**Project Name: Circle A Subdivision Special Use**

**Project Number: MS 207**

**Description:** Circle A Subdivision, Filing #1 is proposed to subdivide an approximately 15 acre parcel with three (3) residential lots. Currently there is a residential home located on what is proposed to be Lot 1. This subdivision is located north of Hodgen Road and west of East Goshawk Road in Section 23, Township 11 South, Range 65 West.

FINAL PLAT
CIRCLE A SUBDIVISION FILING NO. 1
JOB NO. 70-072
DATE PREPARED: 07/15/2019
DATE REVISED: 01/27/2021
DATE REVISED: 05/12/2021
DATE REVISED: 06/02/2021

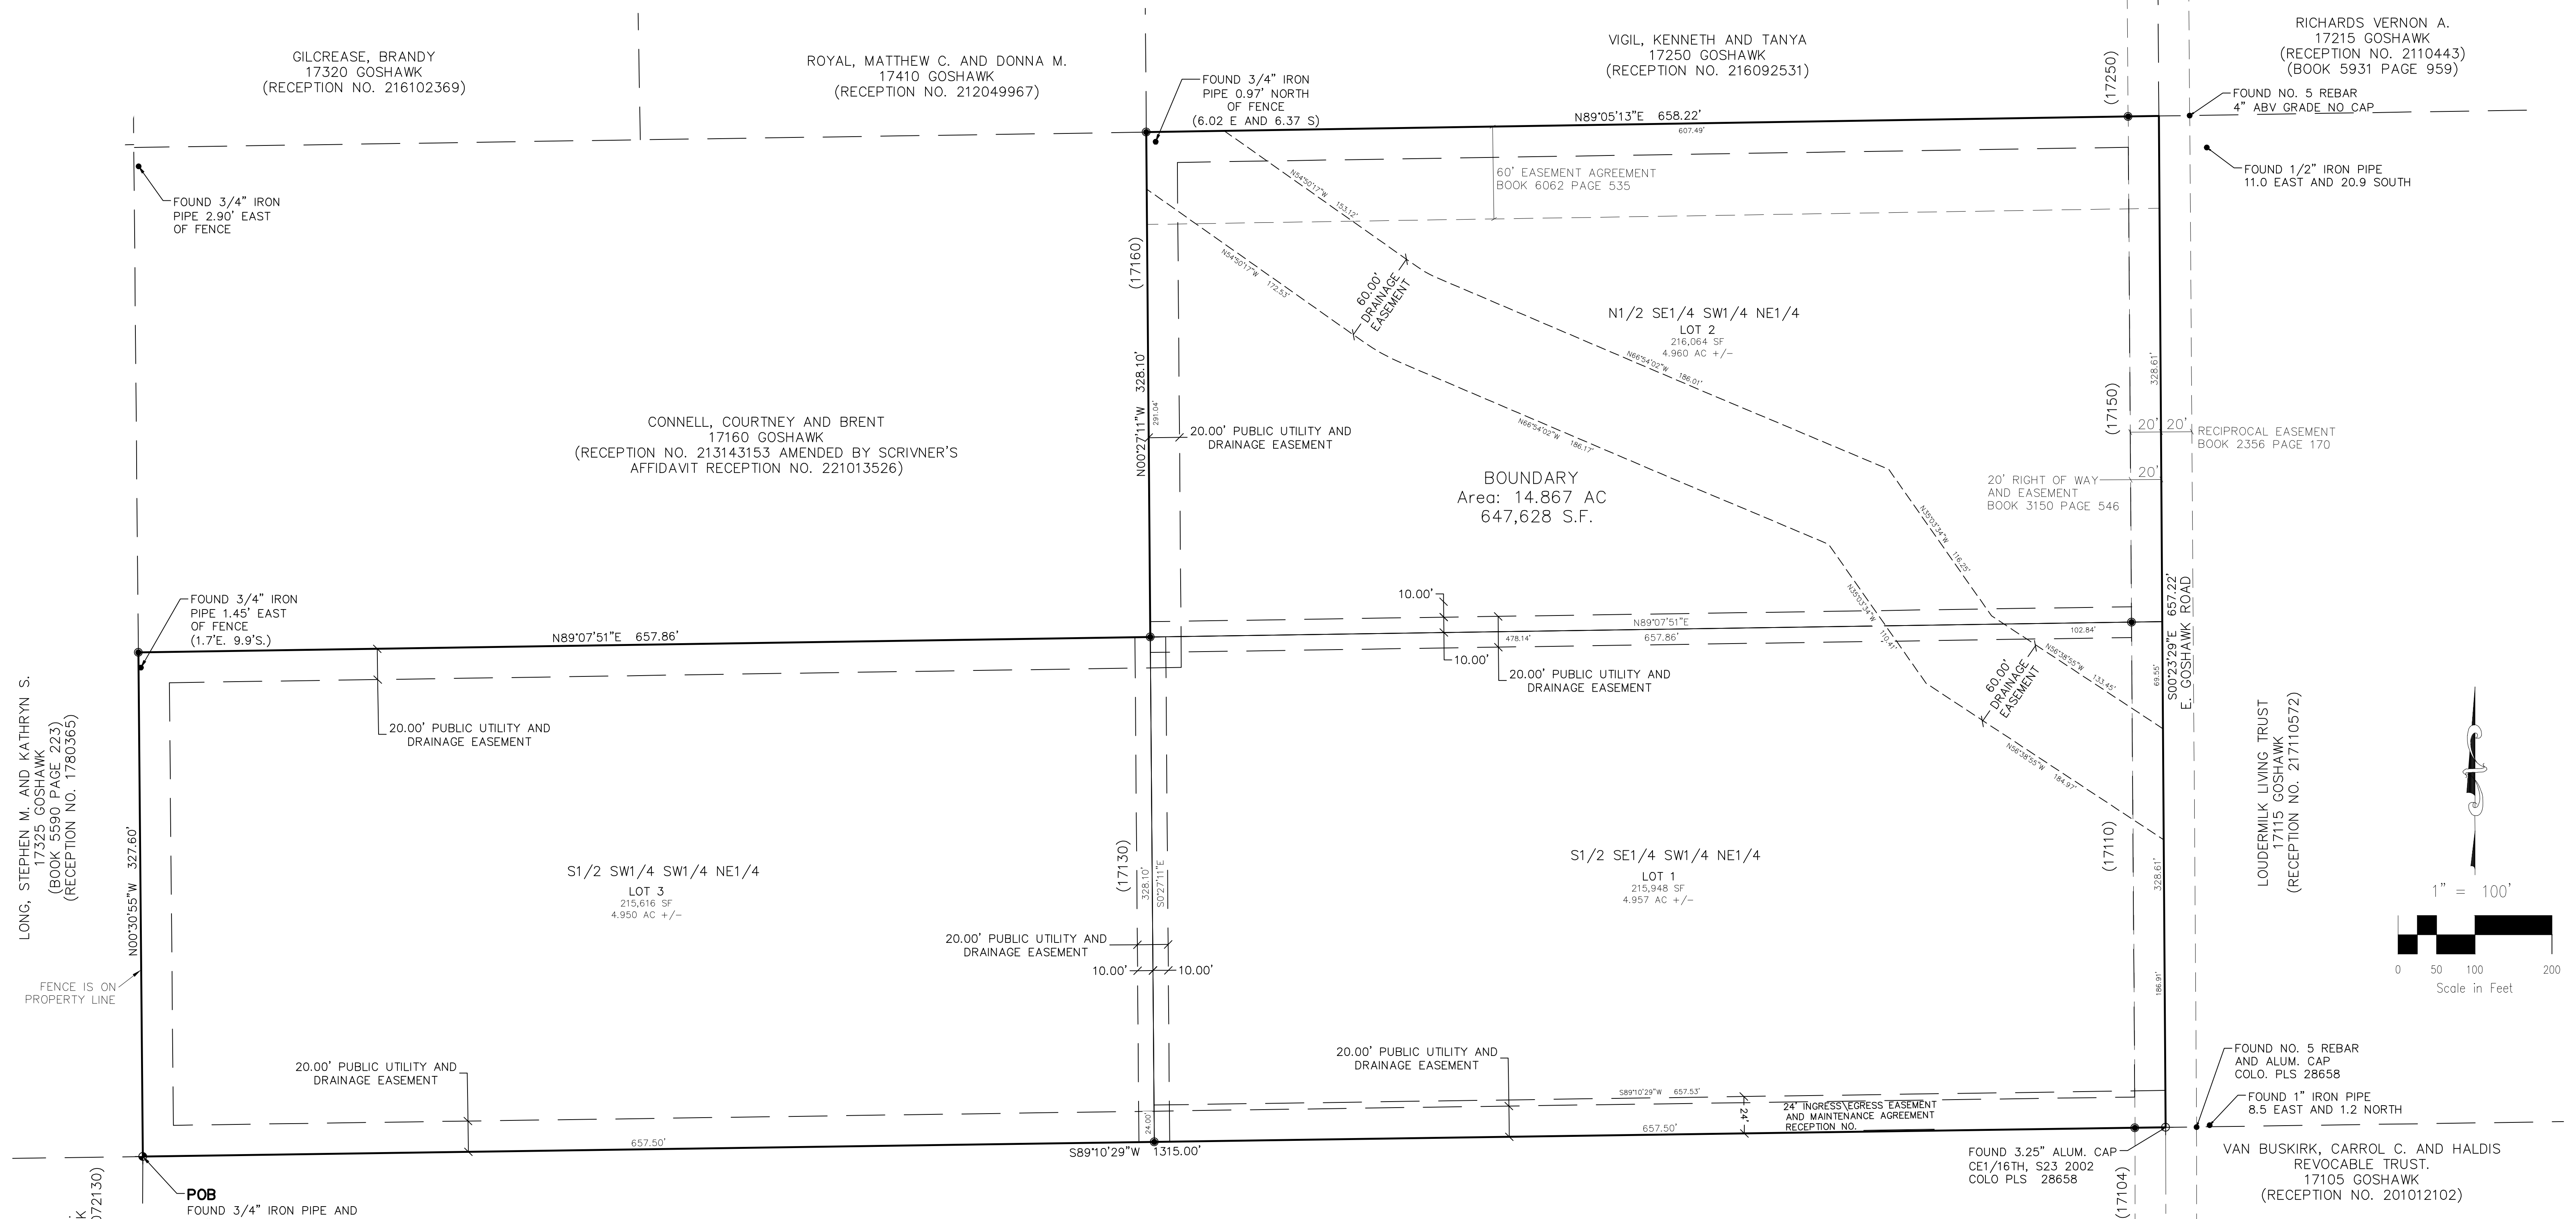
MVEA requests a ten (10) foot utility easement along all common side lot lines and a twenty (20) foot exterior subdivision utility easement. Additional easements may be required once a review of civil drawings with grading and erosion plan is provided to MVEA in order to serve the additional services..
